CITY OF ALBUQUERQUE

3-26-24

Re: Ideal Vacuum Products, LLC
5920 Midway Park NE
Site Plan
Architect's Stamp 2-29-24 (E17D041D)

AS101

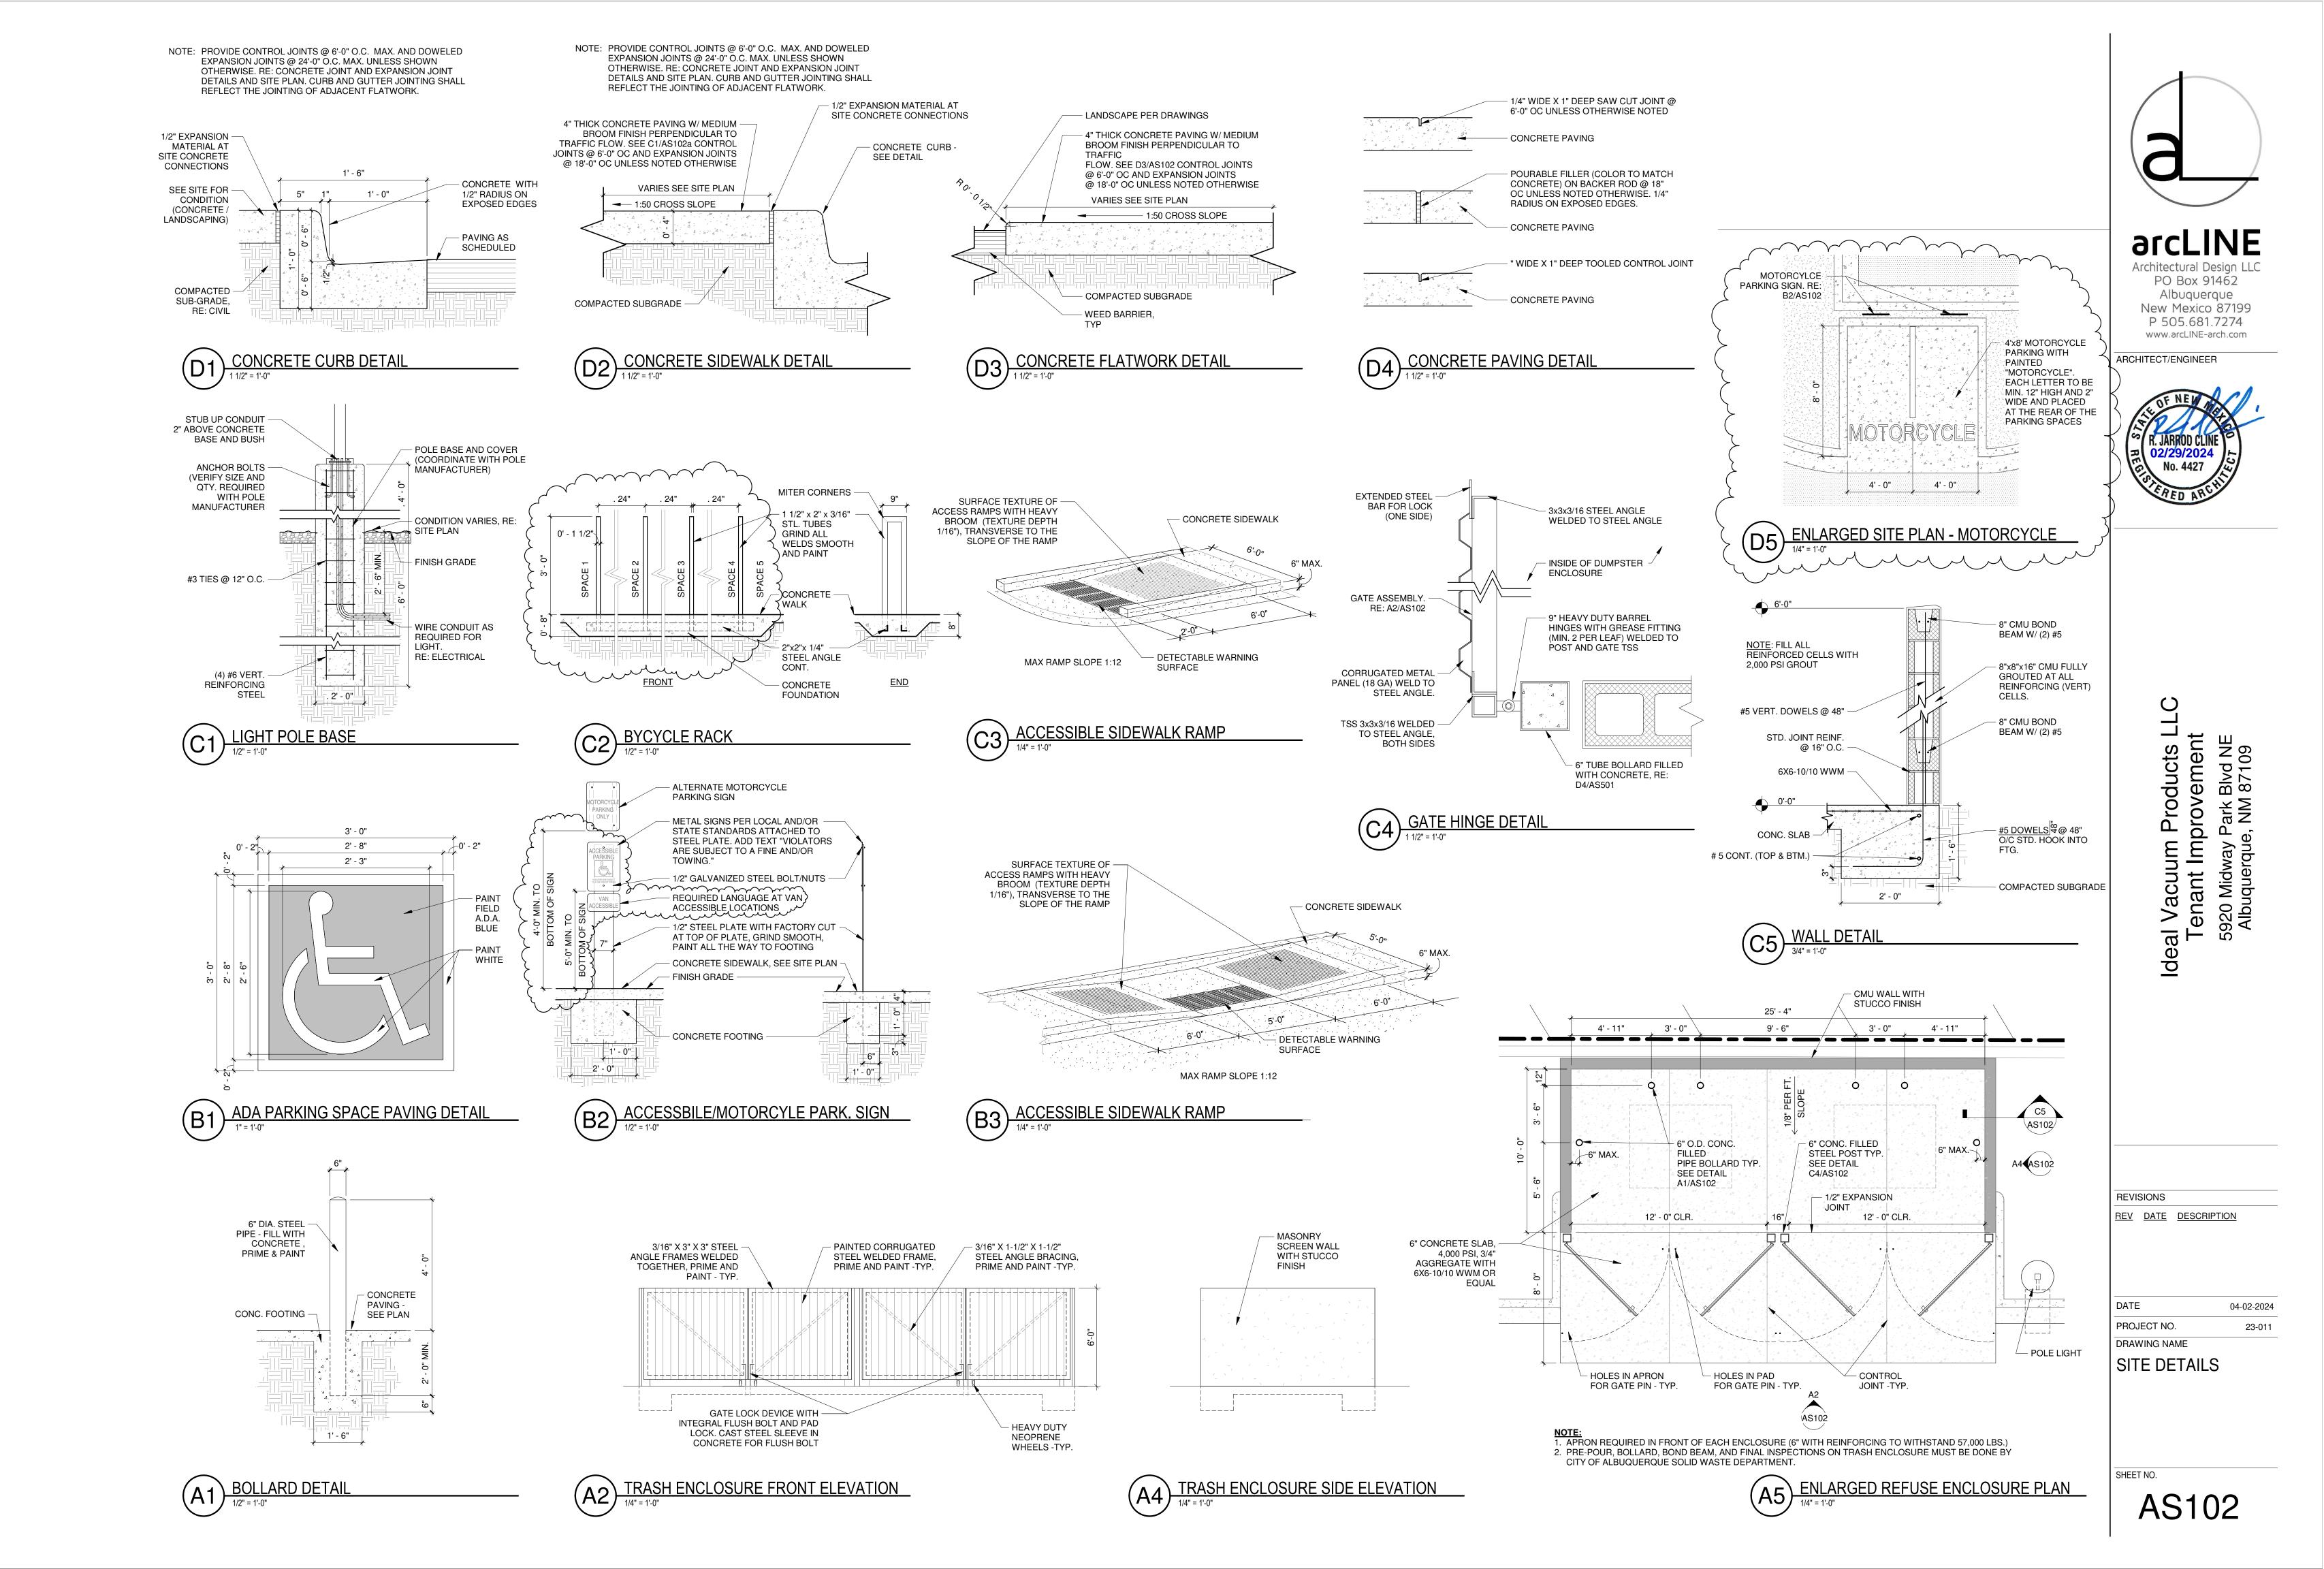
1. It appears the keyway in the North parking lot may be 5' deep due to the 4' radius, but please clarify with a depth dimension.
2. Provide drive aisle widths west and north of the building. The north-south aisle closest to the building does not appear to be the minimum of 22' wide for 2-way traffic.

3. The loading dock in the front of the building may create conflicts with the retail/office circulation in the parking lot. Provide the size of the vehicle that will be using the Loading Dock and show delivery vehicle travel pattern. This will help determine whether the loading dock will need to be moved to the back of the building/ separated from the retail/office circulation.

4. The southern curb return of the southern drive entrance does not tie properly/provide continuous radius to the curb on Midway Park Blvd. It should look like the northern curb return. This entrance will have to be shifted north.

5. Provide sidewalk widths. The sidewalk along Midway Park Blvd is to be a minimum of 5' wide.
6. Provide parking stall widths.
7. Provide accessible aisle width and depth.

8. A 6 ft. wide ADA accessible pedestrian pathway is required from the Public sidewalk to the building entrance(s). Please clearly show this pathway and provide details.

9. For the van accessible parking space, add the "Van Accessible" sign (see attached image). I think the "Van No Parking" pavement markings is misleading and it is nonstandard, so these pavement markings can be removed. I attached an image for the DPM.

11. Please discuss what appears to be two bridges across the drainage channel. They do not appear to be for vehicles, but please state the purpose/usage. Since the southern portion is on the adjoining lot, written approval (email or letter) from that property owner is required.

12. Provide the widths of the proposed drive entrances.
13. Provide the size of the vehicle to determine curb return radii of the drive entrances.
14. Provide Fire and Solid Waste Department approvals.

17. Show the clear sight triangle and add the following note to the plan: "Landscaping and signage will not interfere with clear sight requirements. Therefore, signs, walls, trees, and shrubbery between 3 and 8 feet tall (as measured from the gutter pan) will not be acceptable in the clear sight triangle.
